Zoning Division
Marge Schmuckal
Zoning Administrator

November 15, 2005

RE: Joseph Avenue - 172-F-001, 002, 003 - R-3 zone - new single family dwelling - permit application #04-1585

**BOUNDARY SURVEY**

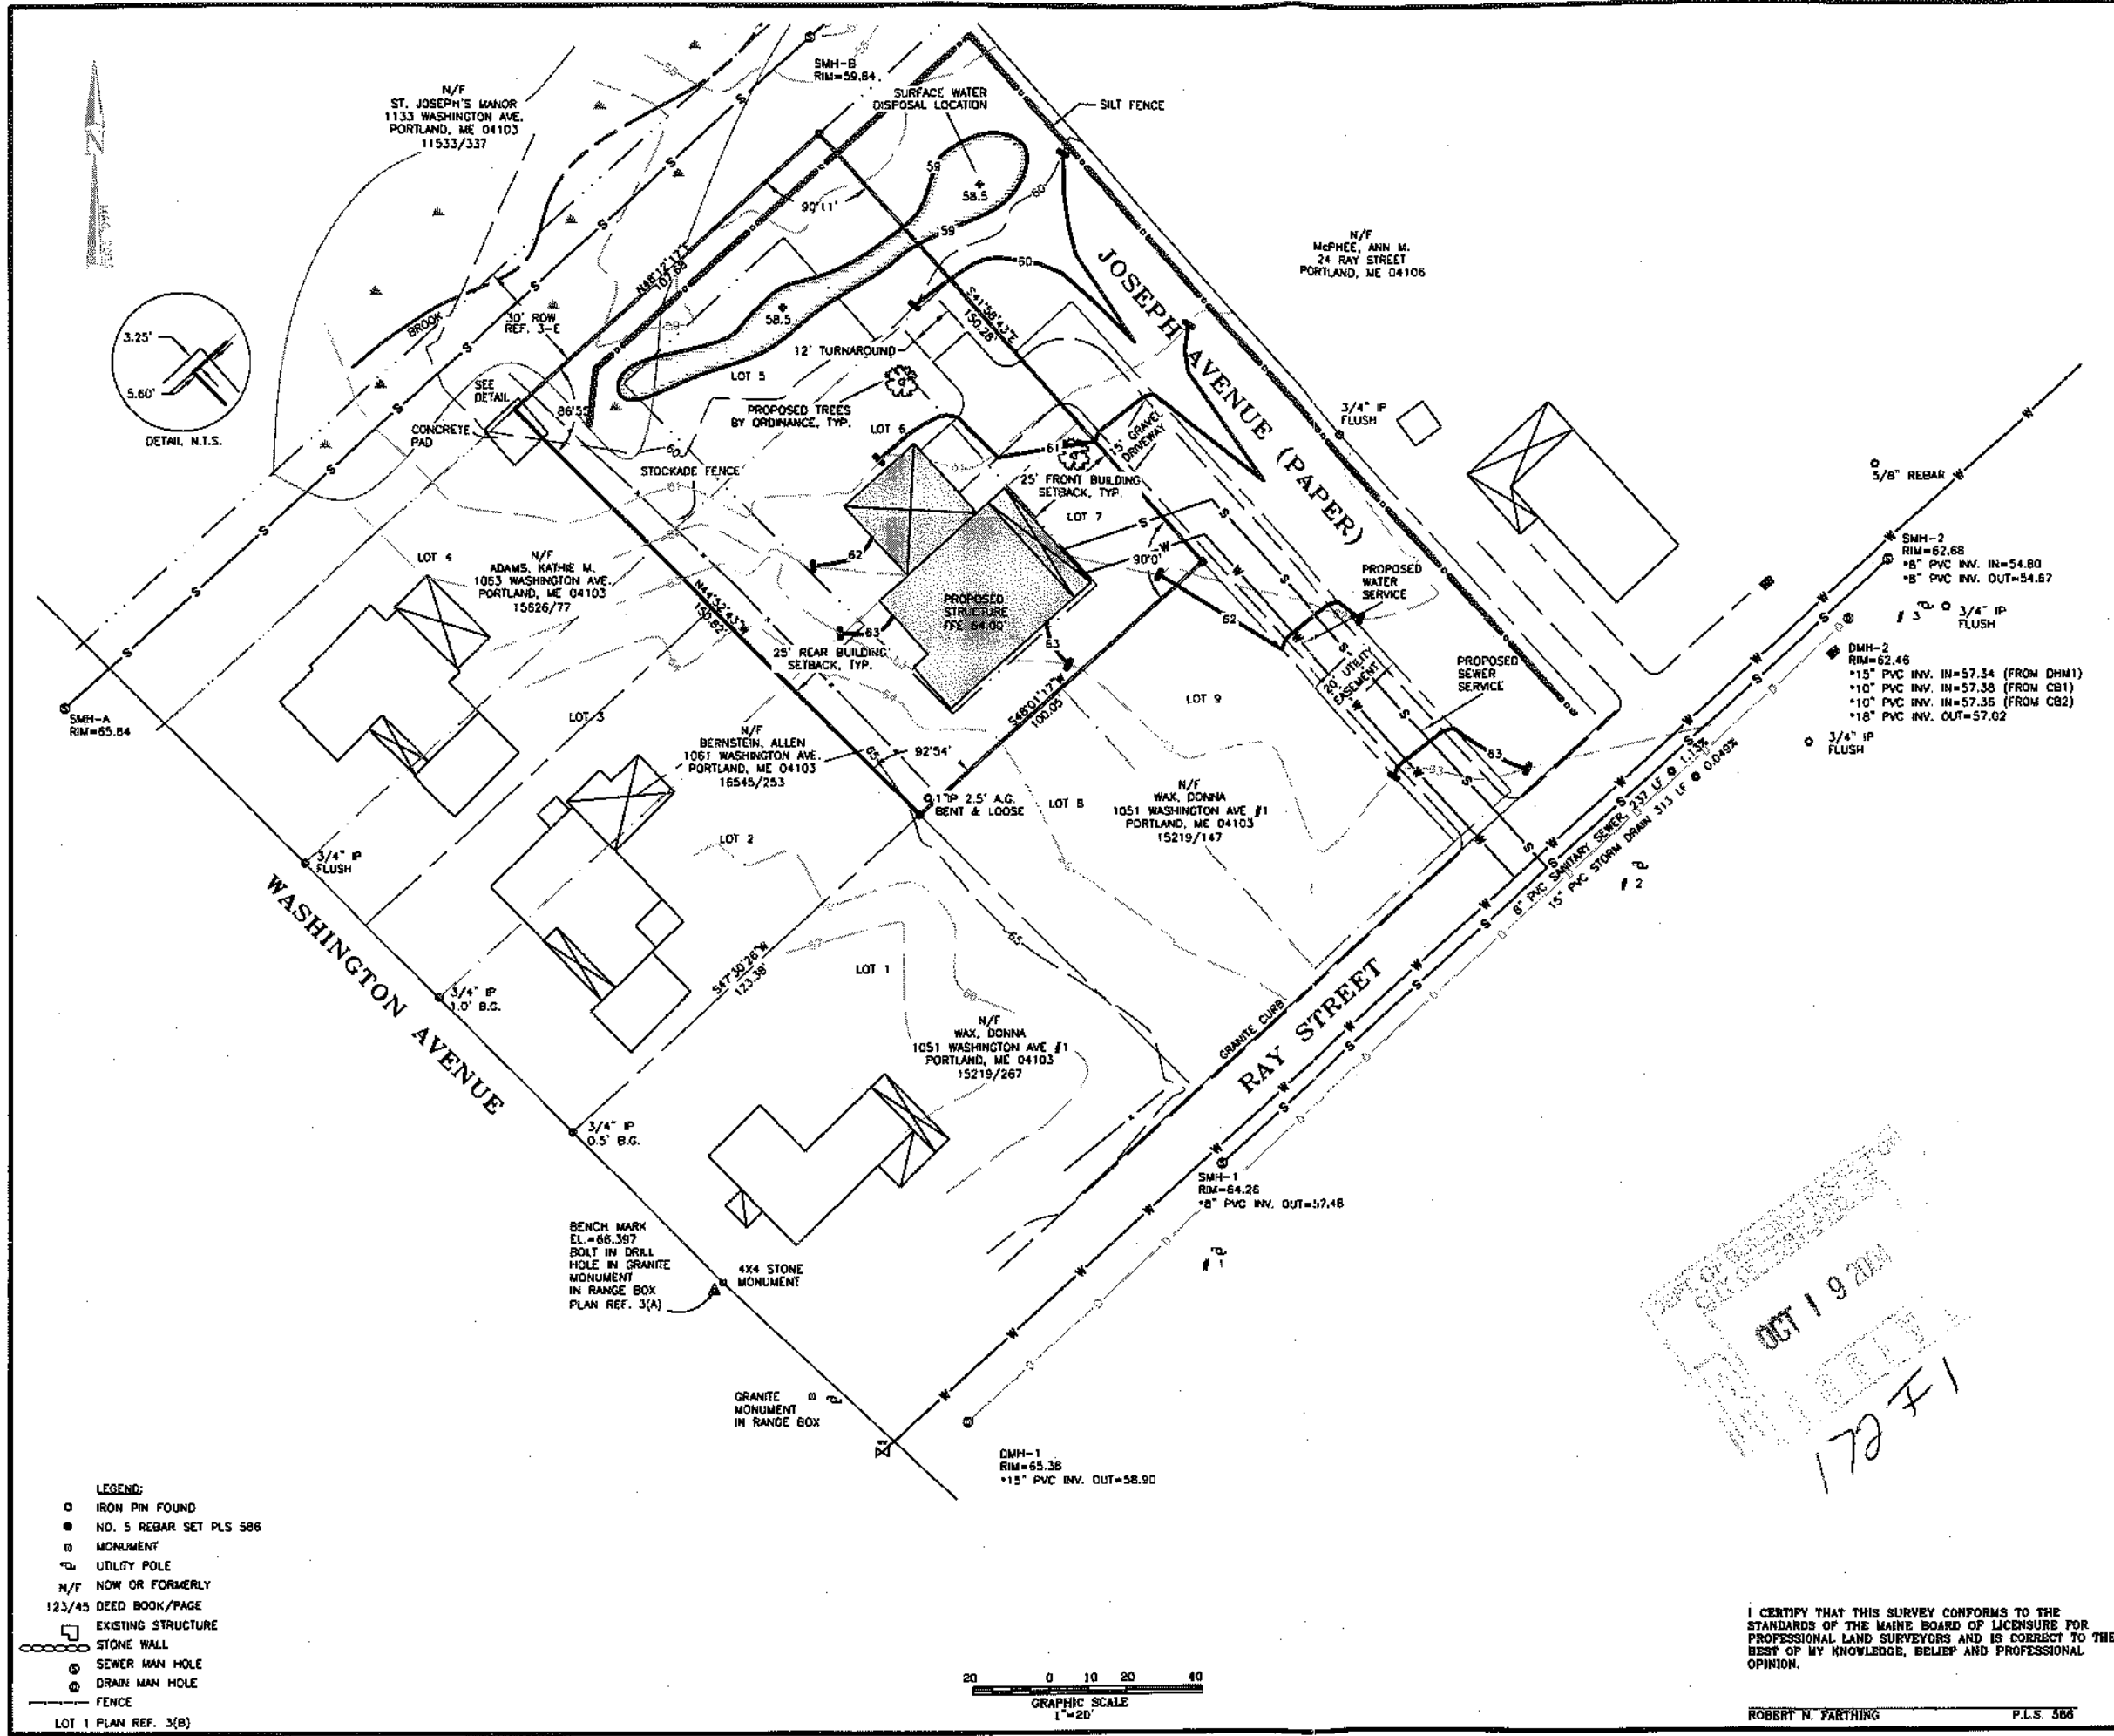
First, your site plan does not match your building plans. All dimensions shall match before a permit application can be adequately reviewed. It is also noted that there is a rear sliding door with no rear deck or stairs being provided. ALL structures that are to be approved as part of this permit application SHALL be shown on both the site plan and the structural plans.

Secondly, Joseph Avenue is a paper street as designated on your submitted plans. Section 14-403 of the ordinance states that the construction of a new housed shall trigger the requirement to upgrade the street to City standards. There is only one exception that this office has not received from you. Section 14-403 states, "The provisions of this subsection (b) shall not apply to the erection of any single-family dwelling on any lot where the owner of the lot establishes that he or she was the owner of that same lot on November 19, 1984, and at all times thereafter, and states his or her intention under oath to make the structure his or her personal residence". Your application submittal did not include such an affidavit. If you believe that all sections of the exemption allowance pertain to your application, it will be necessary to submit an appropriate affidavit to this office. If you cannot meet the requirements of the exemption, it will be necessary to show this office how Joseph Avenue is being brought up to City standards with the appropriate drawings.
